Re: Creamland Dairies (CPN #796681)-Change of storm drain pipe size and type

The change of pipe size and type from an 18" RCP to a 12" DI due to limited cover is approved by Hydrology.

**RE: Creamland Dairies (CPN#796681)
Change of storm drain pipe size and type**

TITLE: **CREAMLAND DORIES
MCKNIGHT AVENUE NW
STA 10+00.00 TO END
PAVING PLAN**

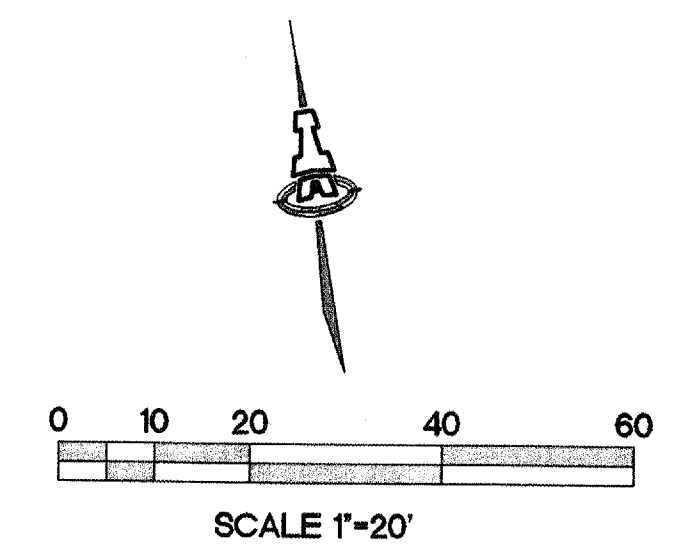
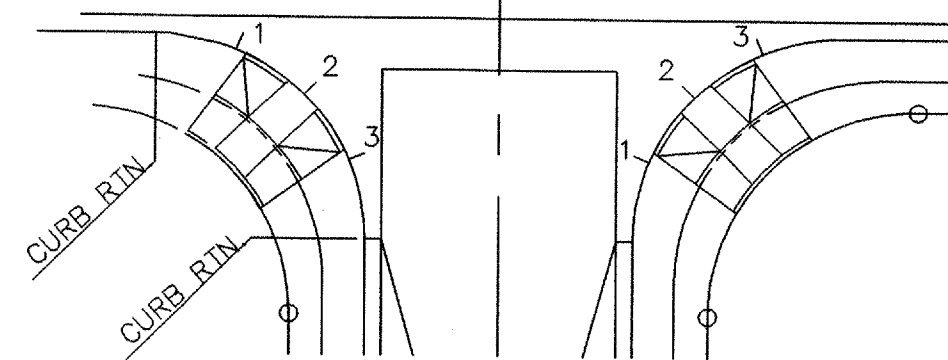
During construction of the Creamland Dairies project, it was found the old, existing storm inlets and lines were extremely shallow. Because the cover over the 18" RCP was so shallow, the new curb & gutter over top of the storm drains would have been pouted with the pipe inside the gutter pan. In order to provide cover over the extension of the storm drains, it was necessary to change the designed 18" RCP storm drains to 12" DI pipes.

This change was discussed with and verbally approved by Jeremy Hoover of COA Hydrology prior to installation.
